From: [White, Lori \(ECY\)](#)
To: [Kelly Bacon \(CD\)](#)
Subject: Swiftwater Parcel and yesterday's site visit
Date: Friday, April 16, 2021 11:05:07 AM
Attachments: [image001.png](#)

Thank you for meeting me onsite yesterday, April 15, 2021, to review the project parcel and defined wetland area based on the Sewall Wetland Consulting, Inc. report prepared for Parcel #15445 by Ed Sewall on the 25th and 27th of August 2020. Ecology requested a joint site visit with a County representative to review the parcel to help answer some questions that arrived based on the information or lack thereof found within the report.

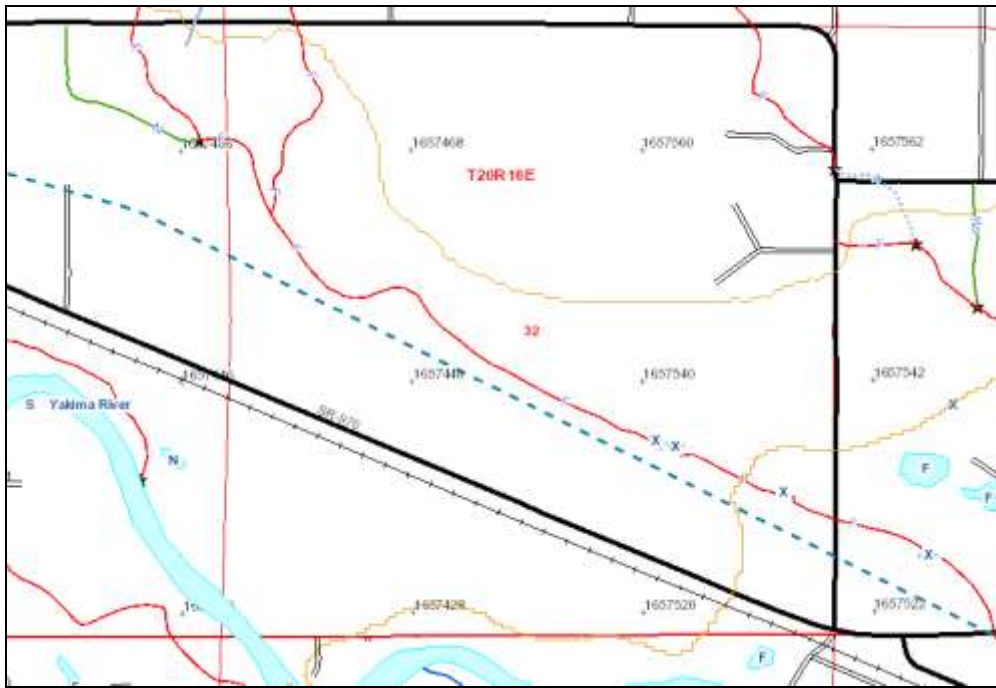
While reviewing the critical area report prepared by Ed Sewall on October 12, 2020, Ecology staff noted a lack of detailed information and an outlined boundary of the delineated wetland. The majority of datasheets provided indicated upland areas and only one datasheet was provided which indicated the presence of a wetland, which was associated with the stream. No data sheets were provided for the interior wetland. Upon review of this area yesterday, Ecology would like to ask the consultant to provide a narrative as to why they determined the westernmost boundary in the forested area to terminate where they placed it and not to continue the wetland boundary further west, as many of the characteristics appears to be the similar approximately 50 to 100 feet west of the wetland boundary flagging.

It appears much the area that was once wetland no longer holds water long enough to meet the standard characteristic of a wetland. This may be the case on the west end of the delineated wetland. I look forward to receiving the additional information from Mr. Sewall.
